Submission ID: S4DBA58F7

Norwich to Tilbury N2T 2nd Consultation response

Faulkbourne Estate suggestions/requests

HILLY TB100 + TB99

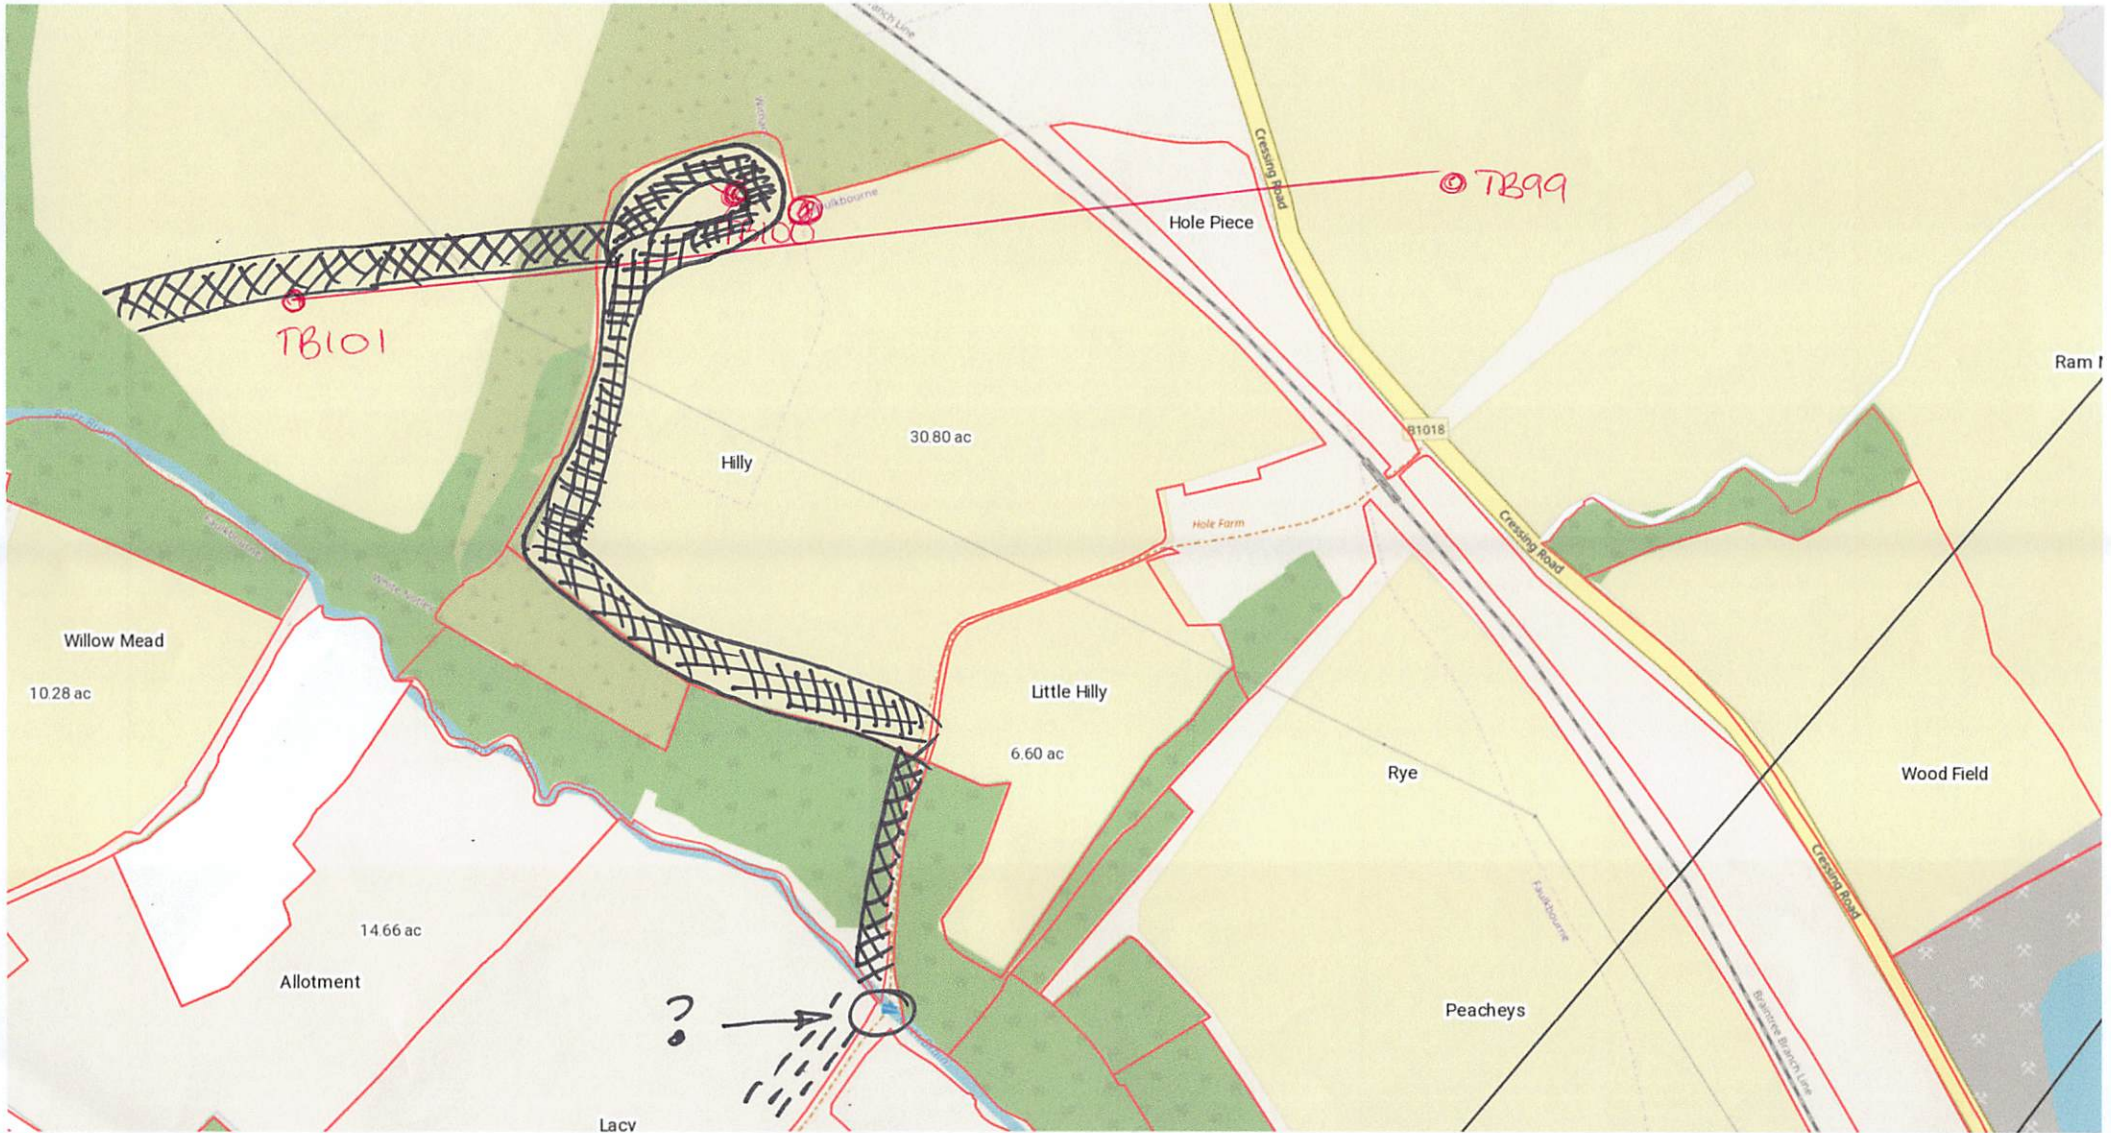
- 1.2.7 Hilly (TB100). As suggested above there is no need to access this field from Grove Ford; you are already building a bridge to access TB101 and that can be used to access TB100. You can build a turning circle in the rough grass in the northern corner of the field. (**see Map 1**)

- 1.2.8 If access across the Grove Ford is deemed necessary then the track should go around the bottom of the field so as not to disrupt the lives of the community at Hole Farm (**see Map 1**)

- 1.2.9 How will a bridge be constructed across the ford which rises 8 ft (over the existing footbridge) and widens to 50 meters in the winter

GROVE TRACK ACCESS

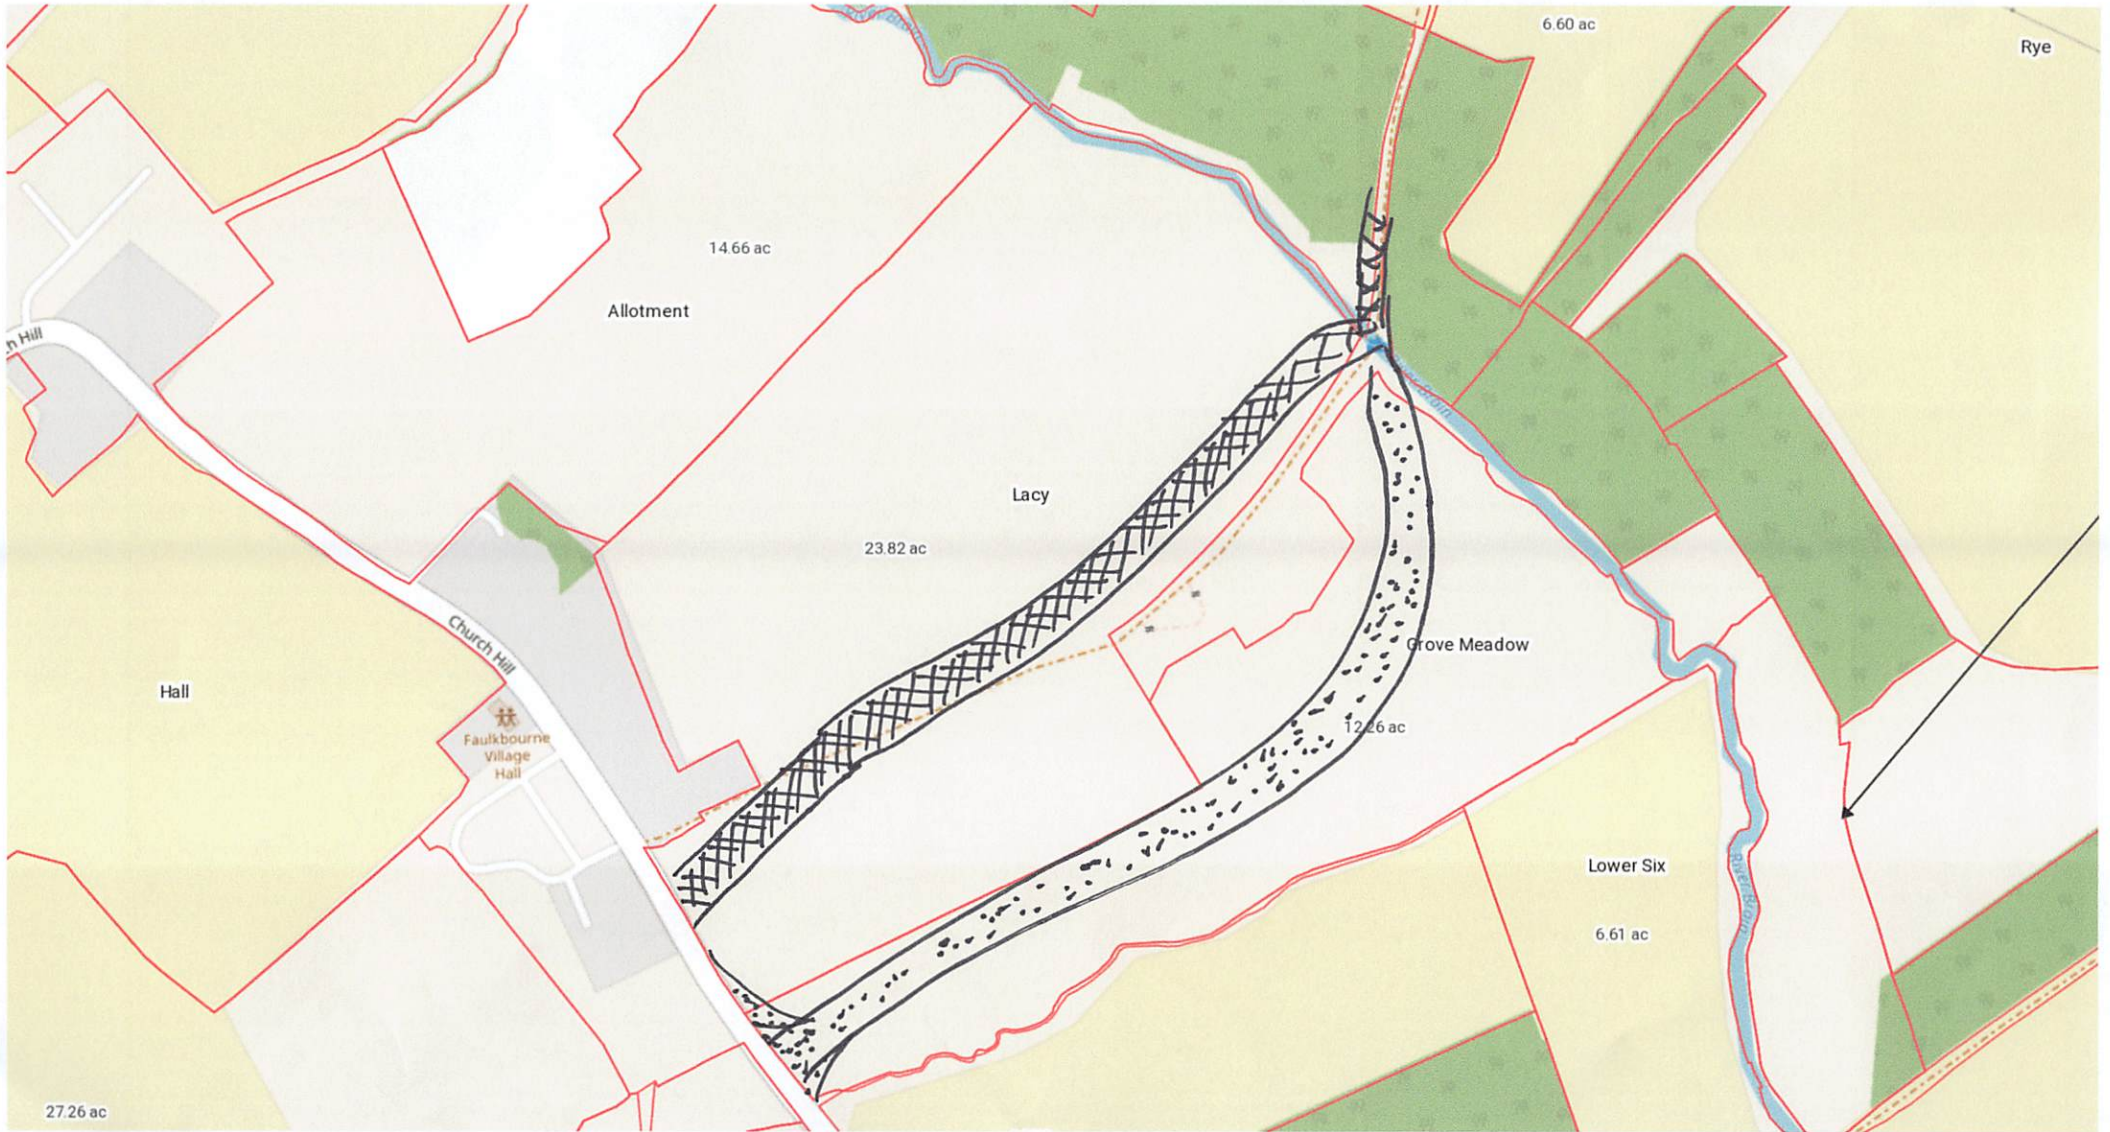
- 1.2.4 **The proposed haul Road down Grove Track is very disruptive and is wholly unacceptable.**
- 1.2.5 Grove Cottage and Grove House are presently let but will become unlettable if they are on the edge of a new Haul Road. Their cars use Grove Track for access.

- 1.2.6 The entrance to Grove track is blind particularly to traffic coming from the north – sadly cars come through at over 70mph despite the speed limits

- 1.2.7 The Road widening measures proposed to the south of the entrance will not assist are require a huge amount of earth to be moved
- 1.2.8 The edge of Grove track contains allof the water, broadband and electricity pipes for not only Grove House and Grove Cottage but also for the Hole Farm community across the River Brain

- 1.2.9 School House parking is at the edge of Grove Track and indeed it is where they keep their cars. The Old School also have entrances on to Grove track

- 1.2.5 If a Haul Road near Grove track is pursued then it should be either be down Grove Meadow, the pasture to the South – see dotted track on **map 2**- or in extremis move 30 metres into the field to the north of Grove track so that it does not go past the entrance to Grove Cottage or Grove House. (see chequered road on **map 2**)

TB102, TB103, TB104

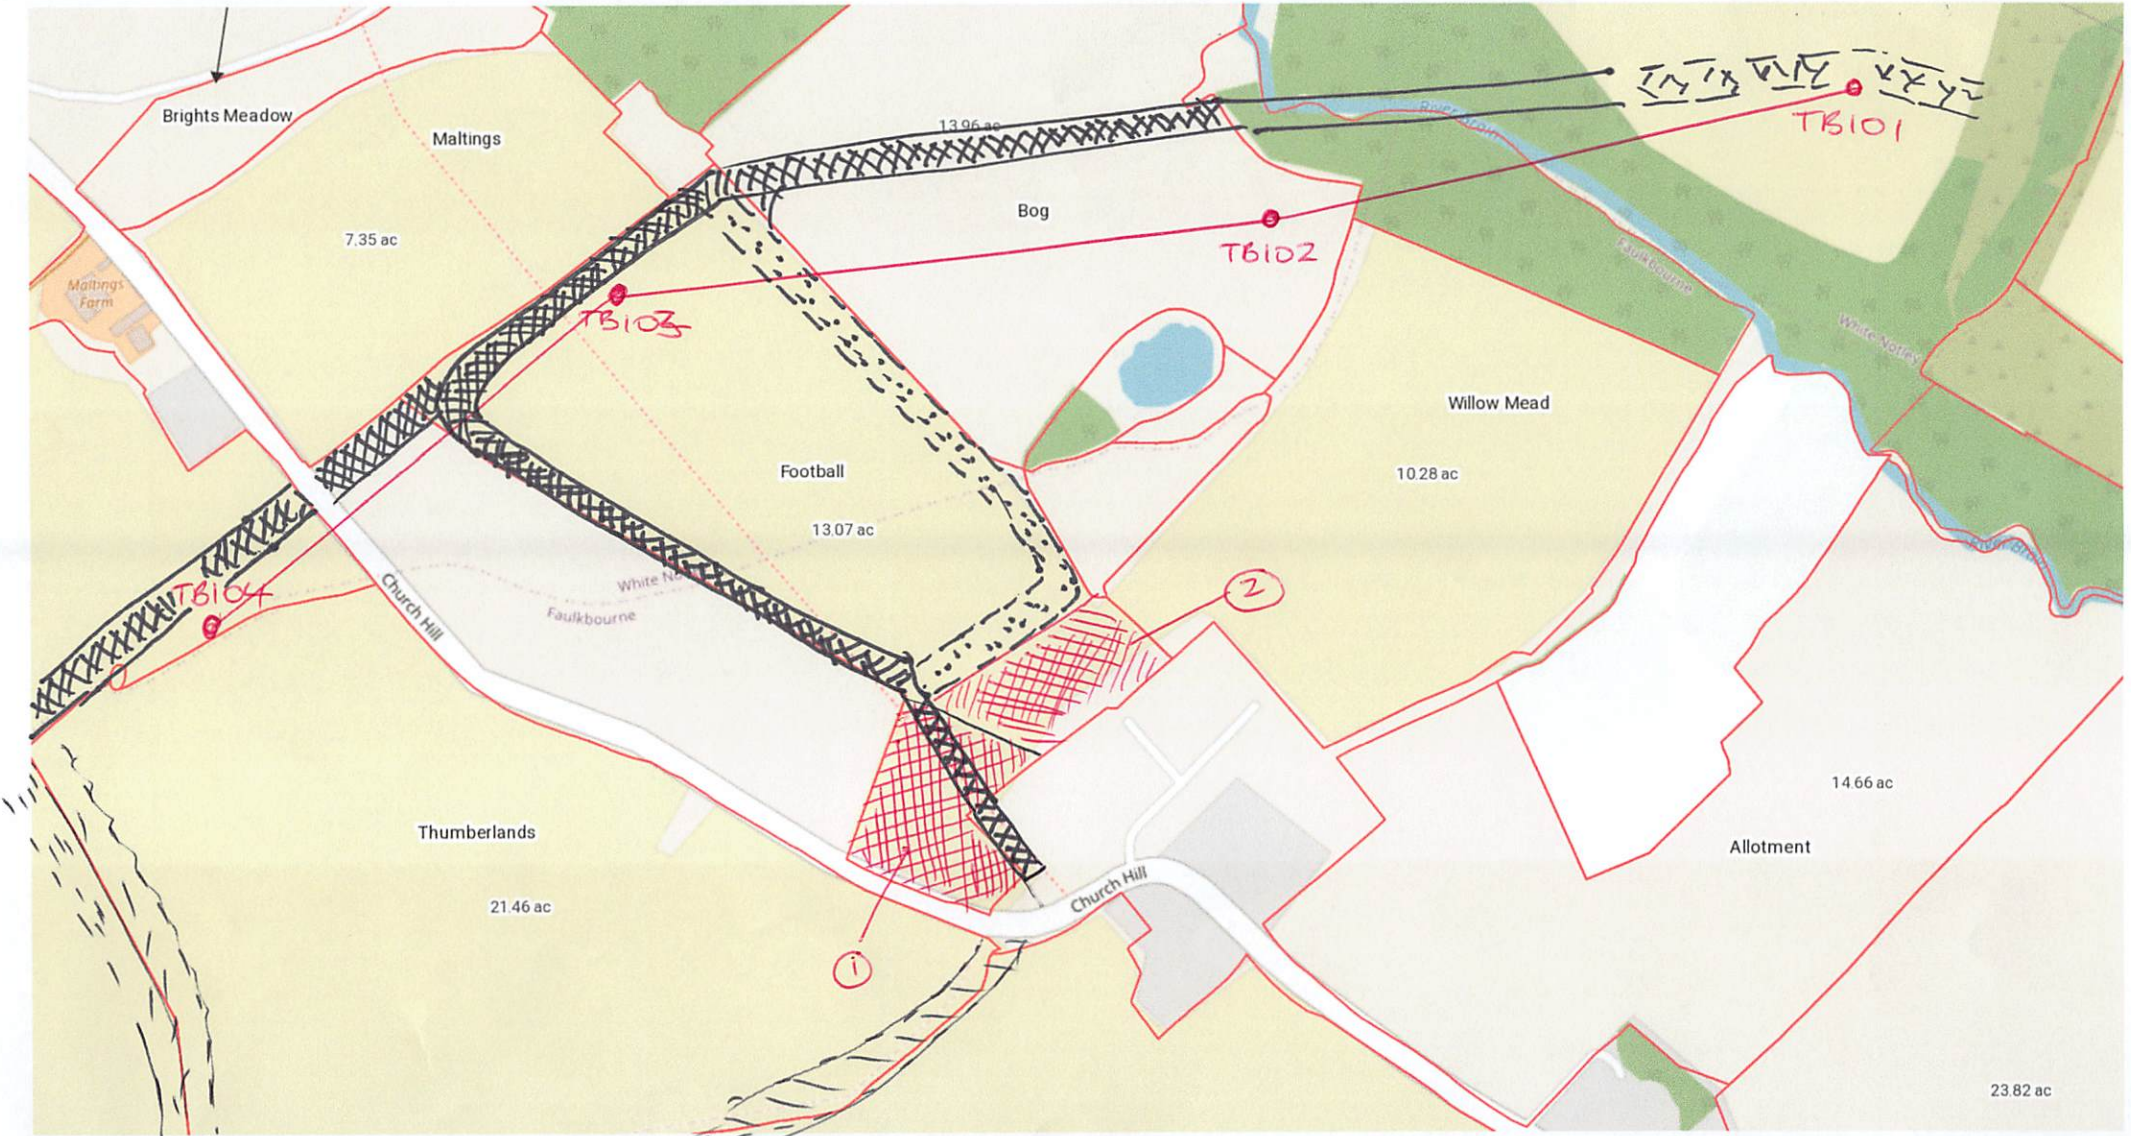
1.2.3. The haul Road could then go along the hedge line between the Football club and Football field. **(See map 3)** (chequered path). This already a footpath and would remain after the work has been completed. Alternatively it could then turn East and follow the lower (eastern) boundary of Football field (the dotted path). Both provide similar access to TB103. We prefer the first option.

- 1.3.1 You have proposed creating a new entrance off Church Road through the end of the Football pitch and adjacent to Maltings Cottages. We believe that a better solution is for access to this side should be through the gate opposite Oak Farm Entrance. (See Map 4)

1.3.8 Good access to TB103 is maintained. It would require a drop down from TB103 towards TB104 but it would be less disruptive to the residents at 1&2 Maltings Farm Cottages, Maltings Farm and the various businesses in the farmyard at Maltings Farm (see map 4)

- 1.6 Move from Blueberry to Football south of clubhouse, between edge of hard pitch and bottom of silage clamp- using main gate to the west of Grain Store 1 (see Map 3 marked 1). If more space required extend further west to (see Map 3 marked 2)

TB106
TB105
TB104
TB103

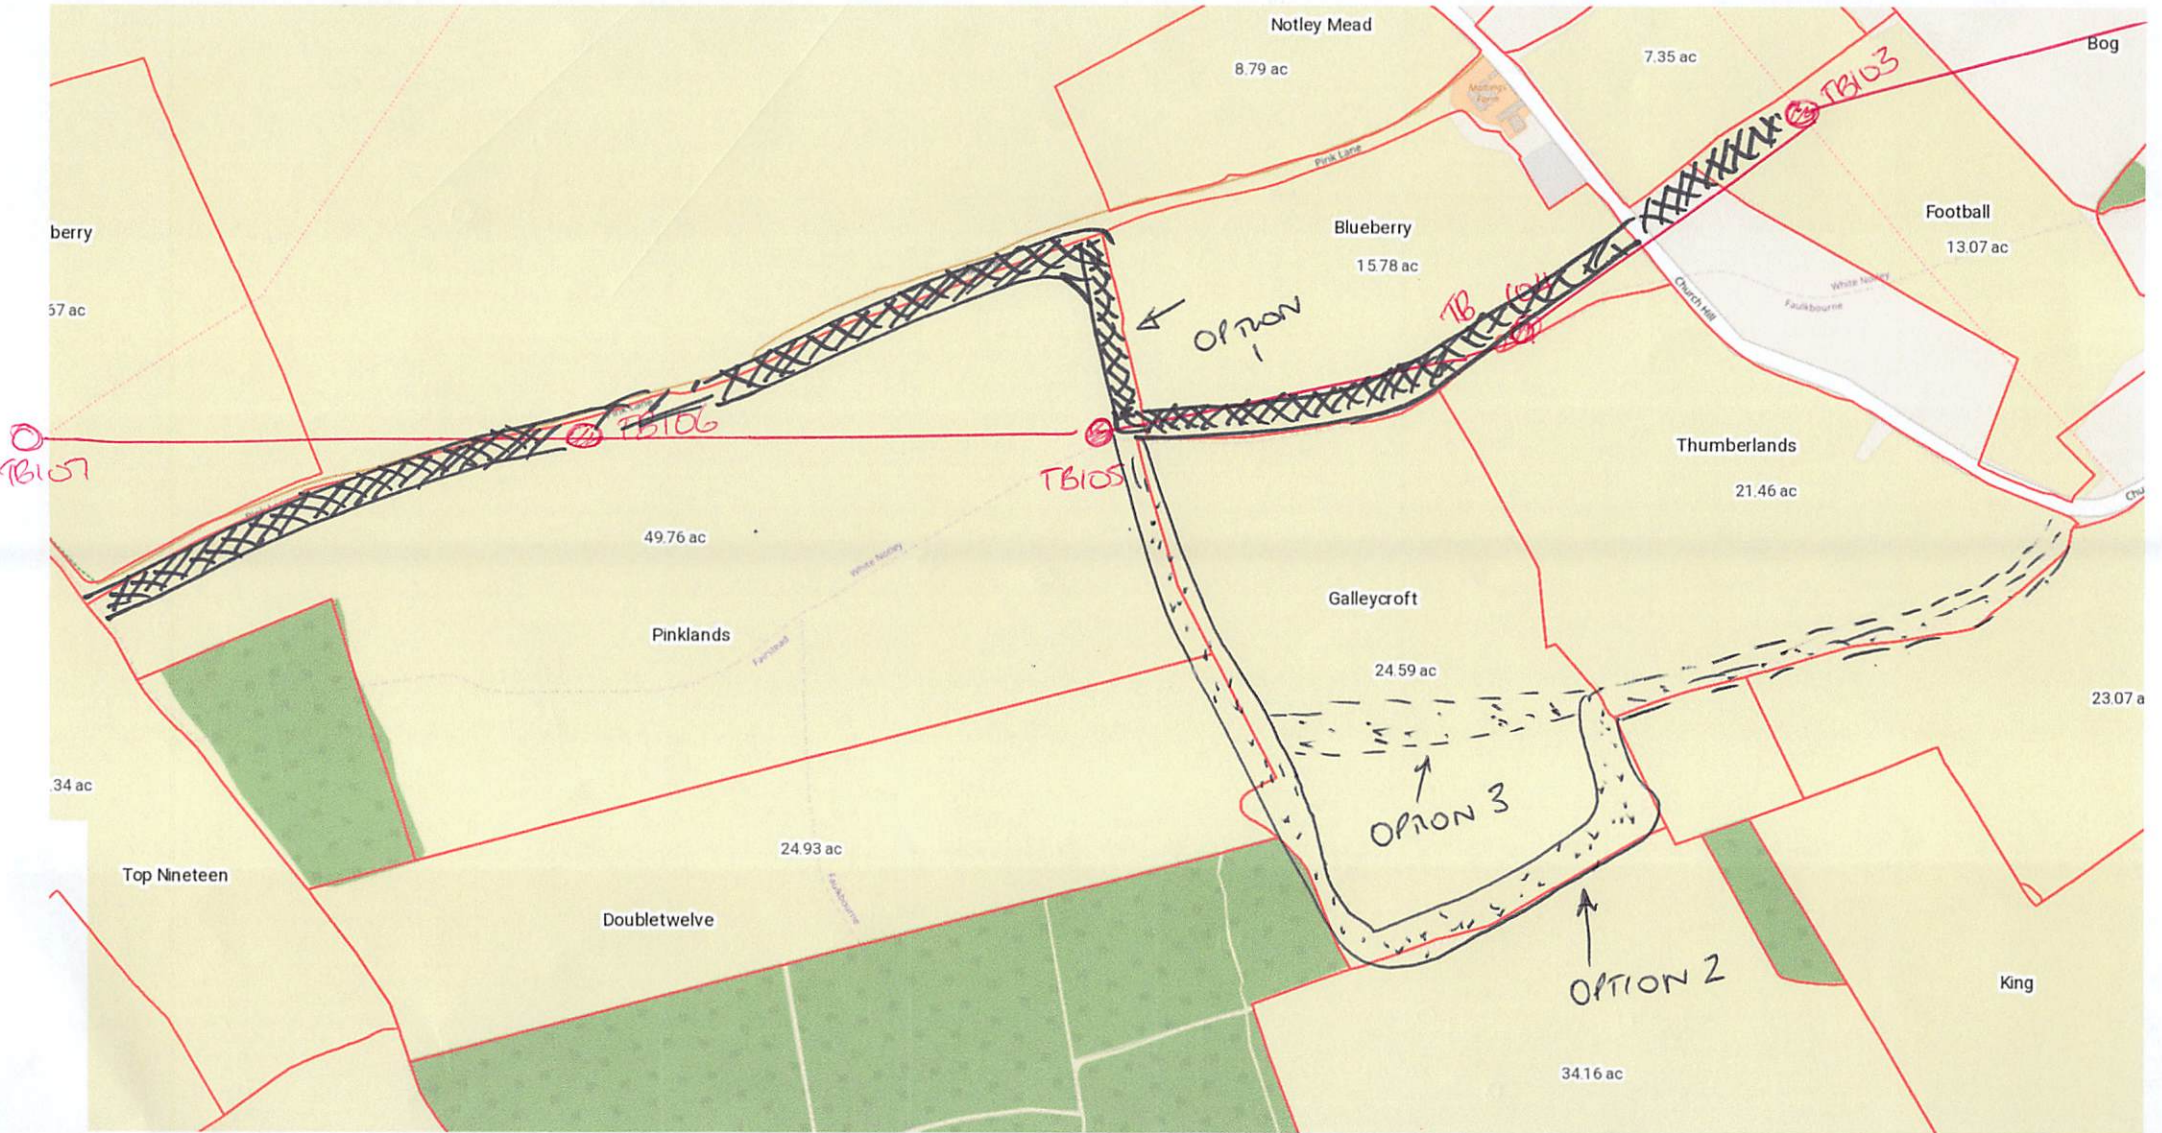
1.3.9 Good access to TB106 can be obtained from Pink Lane (see Map 5)

1.4.1 If the Haul Road continues to the end of Pink Lane before turning right towards TB107 (see map 5) it would use the existing modern farm track and avoid agricultural land and field drains. There would be no need to have a Haul Road across Strawberry and the pylon access to TB107 would be a 30m track from the farm road.

- 1.4.2 The farm road continues to the existing proposed road across LRF land and adjacent to TB108 which could if necessary moved into their field.
(see map 5)

- 1.7.1 Move TB110 into field to the North West (**see map 5**)
- 1.7.2 Move TB108 to the hedge line on North West (**see map 5**)
- 1.7.3 Move TB106 to the hedge of Pink Lane track (**see map 5**)
- 1.7.4 Move TB105 to Tri Corner Junction of Blueberry, Galleycroft and Pinklands (**see map 4 & 5**)
- 1.7.5 Move TB104 to hedge line (**see map 4**)
- 1.7.6 Move TB103 to hedge line North East of Football (**see map 3&4**)
- 1.7.7 Move TB100 (**see map 1**)
 - a) to North East between railway and road
 - b) to edge of railway or towards corner at north point of that field.
